CITY OF ALBUQUERQUE

**RE: Winrock Redevelopment Parking Structure
Drainage Report and Grading Plan
Engineer's Stamp Date 3-7-2015 (J19D058C)**

DATE: 03/06/15	sheet- C100	X
SCALE: 1"=100'	gt	XX

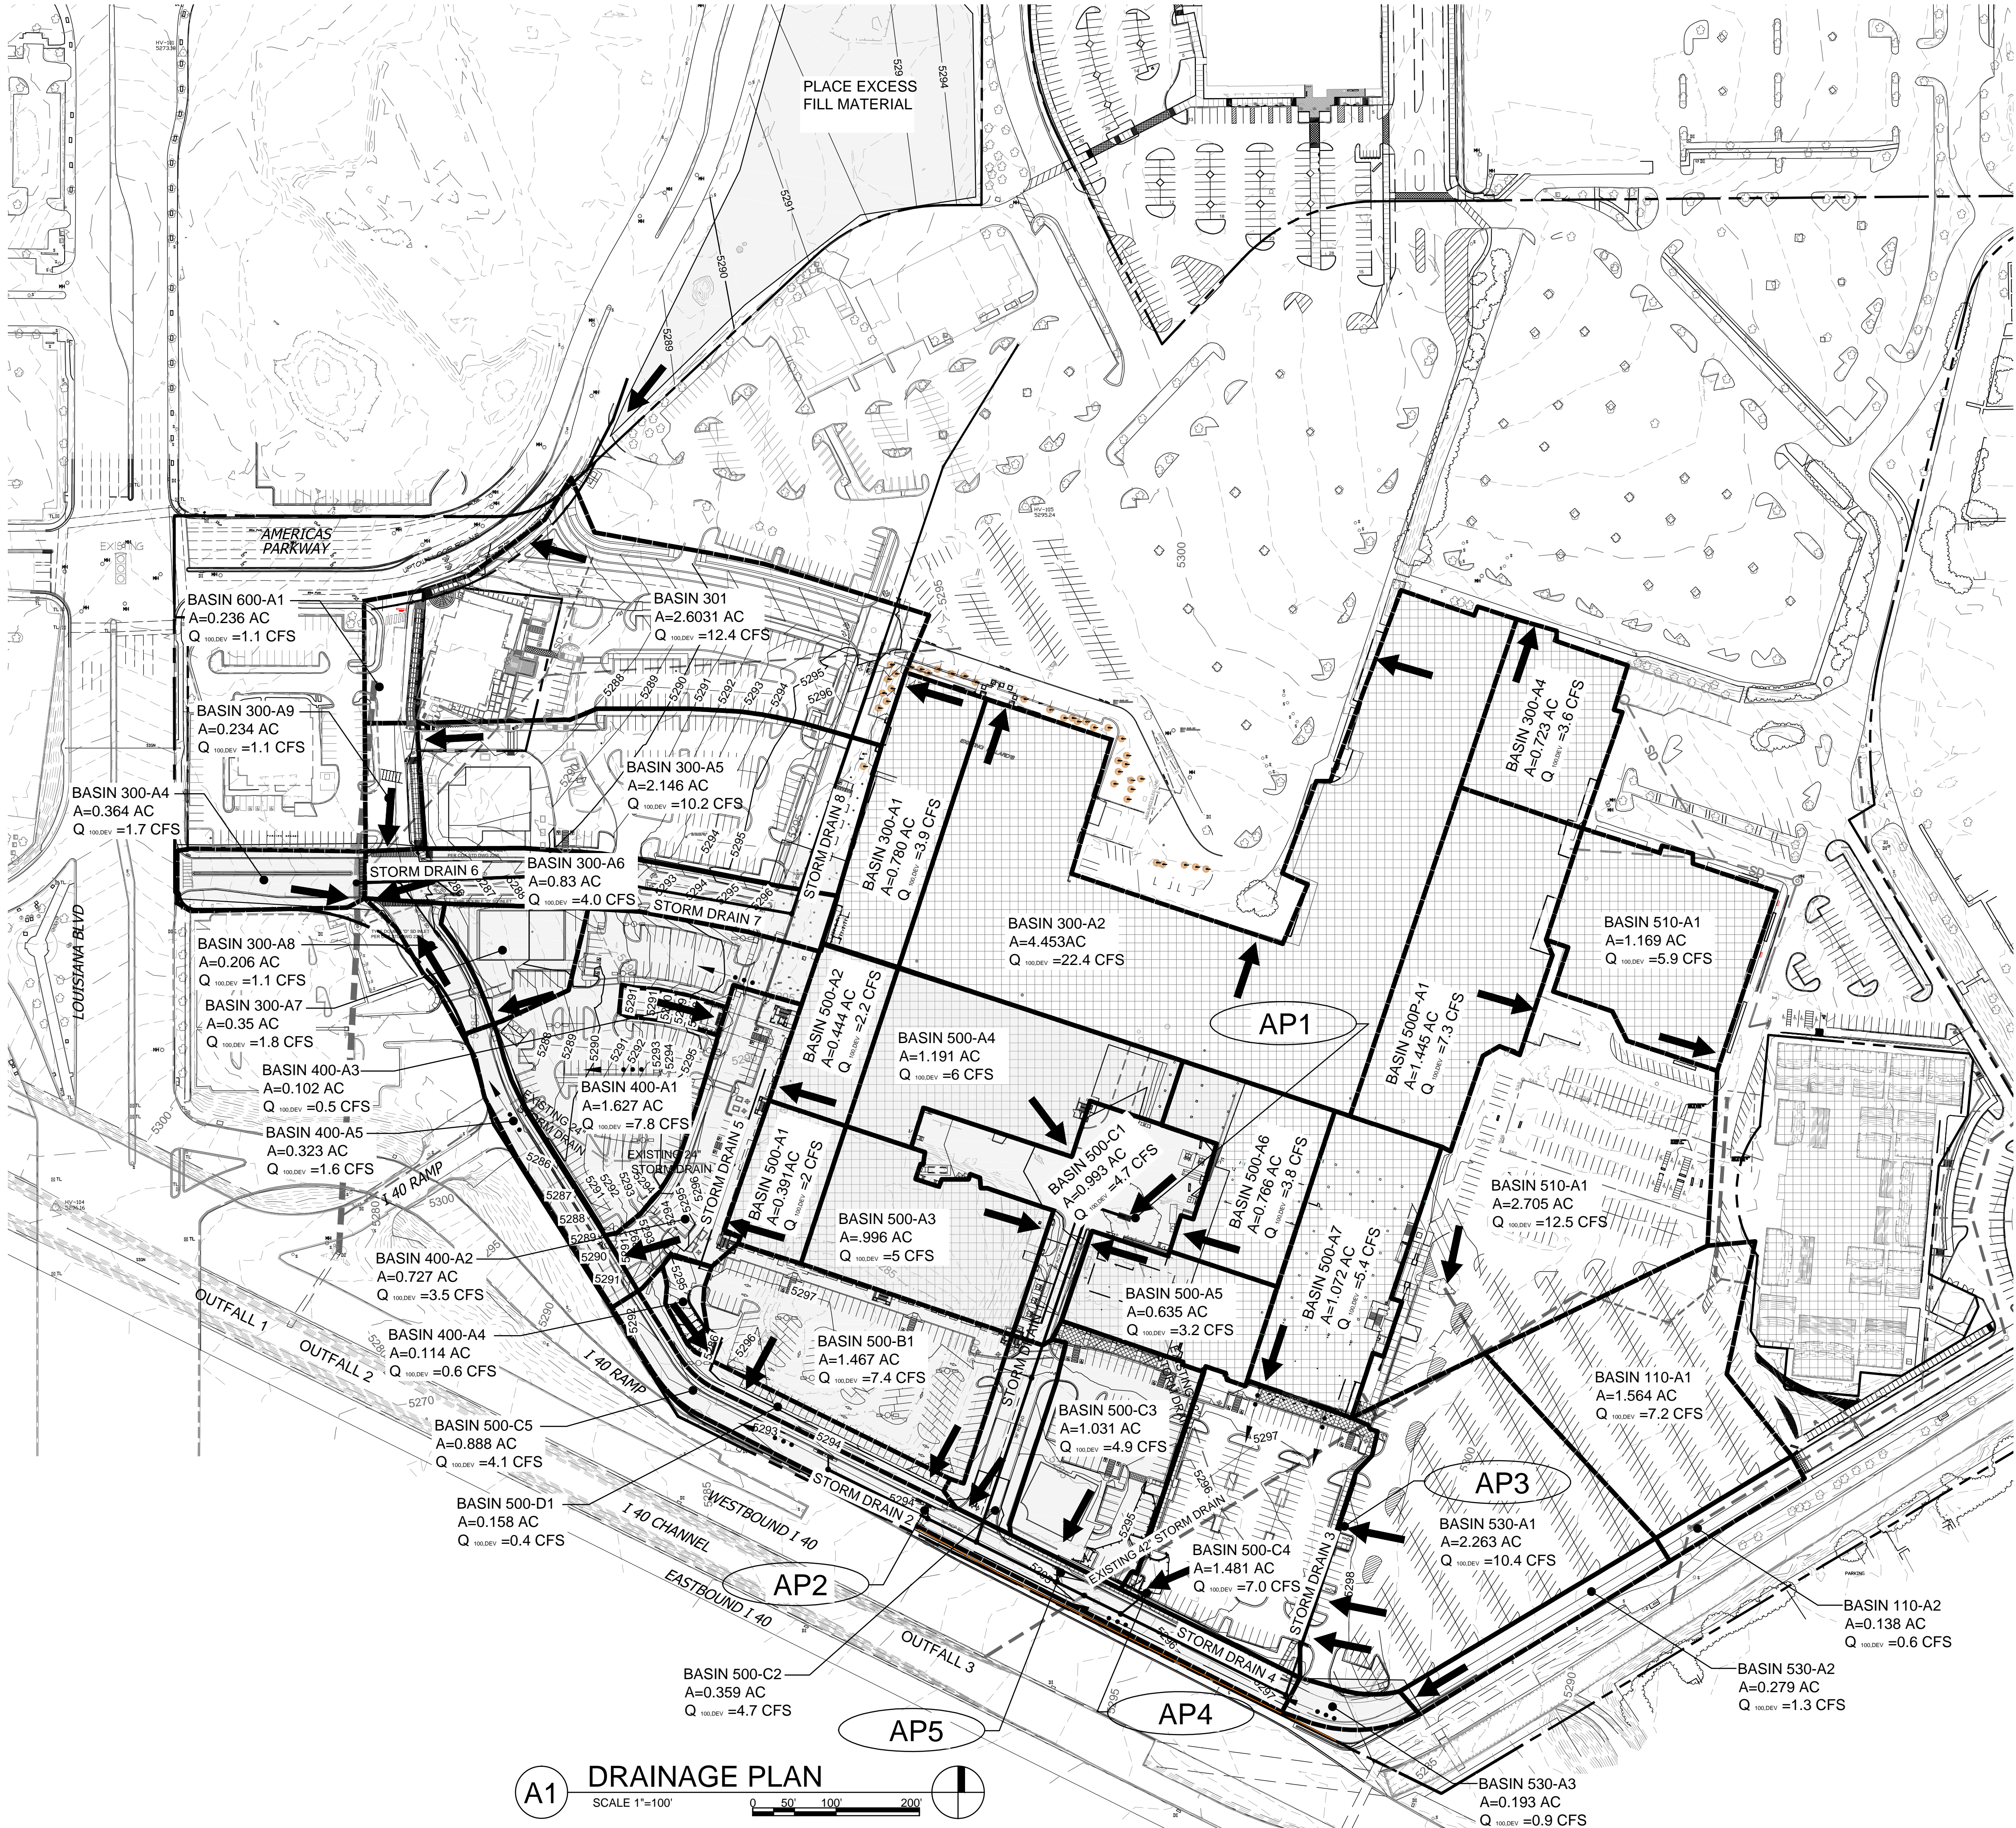
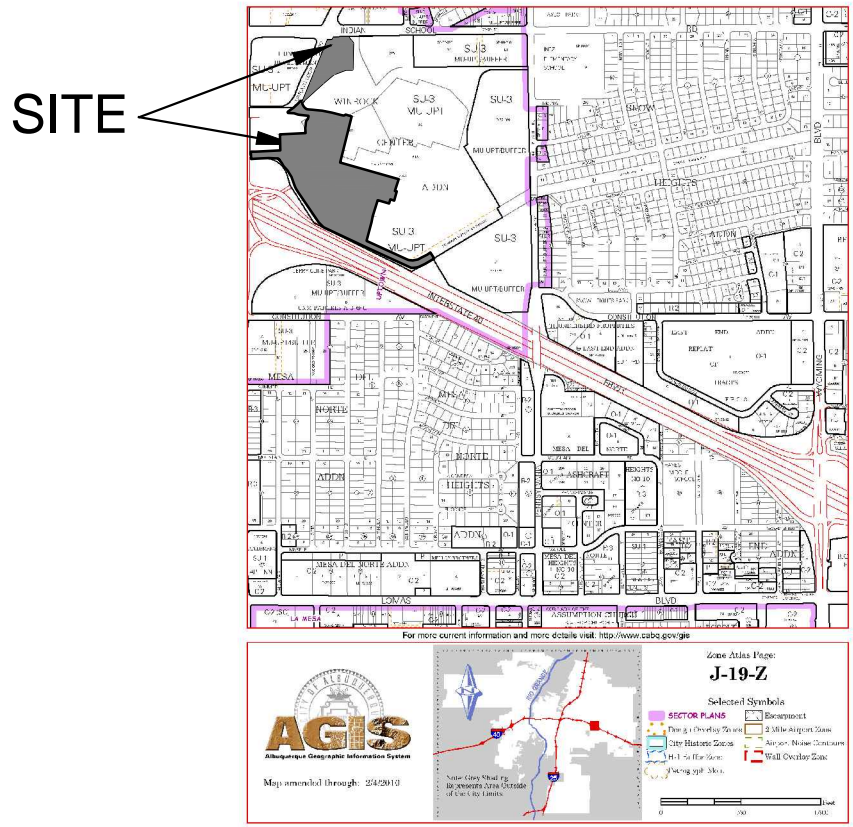
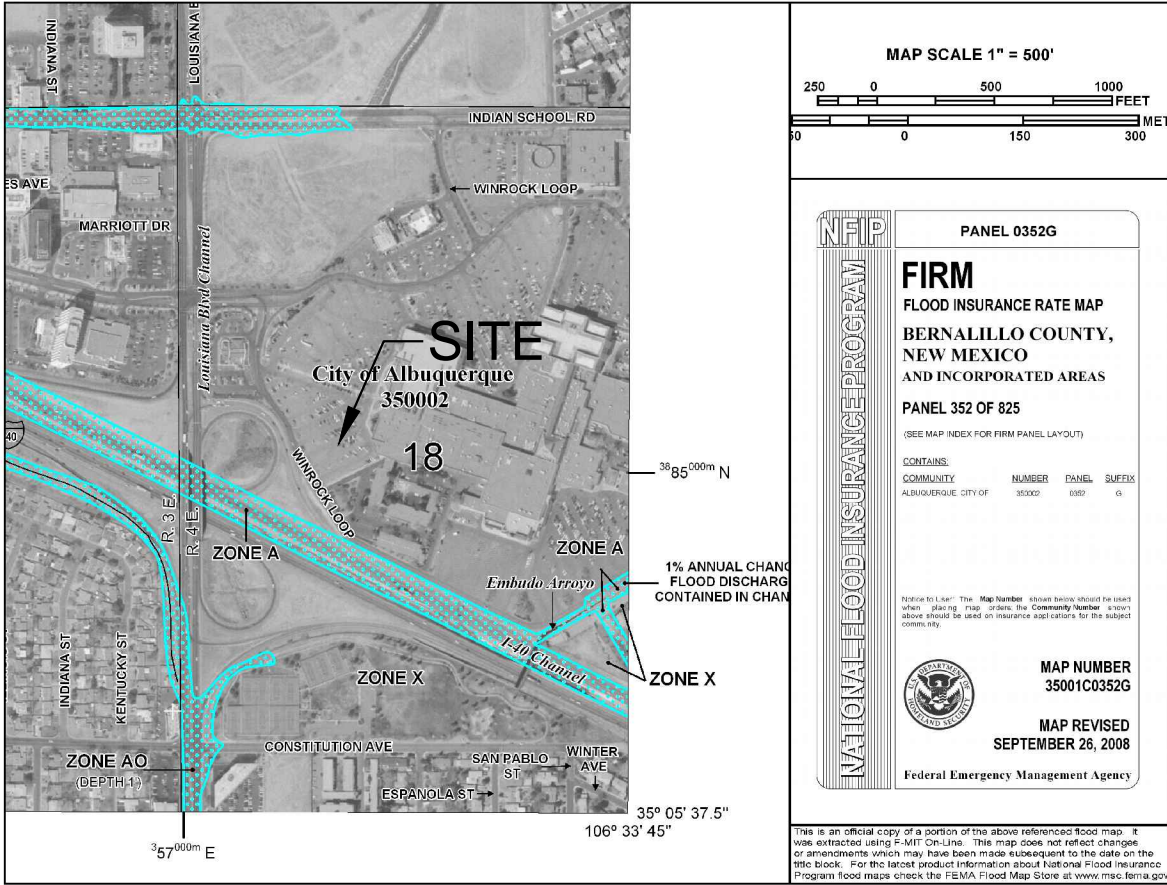
1. There needs to be a plan on how interim phases are to be addressed. See DMP Comment letter, comments 9 thru 12. Please coordinate with Isaacson & Arfman.
2. Existing discharge flowrates (present conditions) need to be determined for comparison to interim condition.
3. There needs to be consistency in localized G&D plans. See DMP Comment letter, comments 13 thru 16.
4. Regarding sheets C103 and C104, Outfall flowrate shown are for the final developed site as studied in the DMP, but do not show the present outfall flowrate, nor the interim condition flowrate.
5. How are pipe capacities determined as shown on C103? Perhaps this is a mute point per comment 12 on the DMP.
6. Basins boundaries need to be consistent with the DMP.
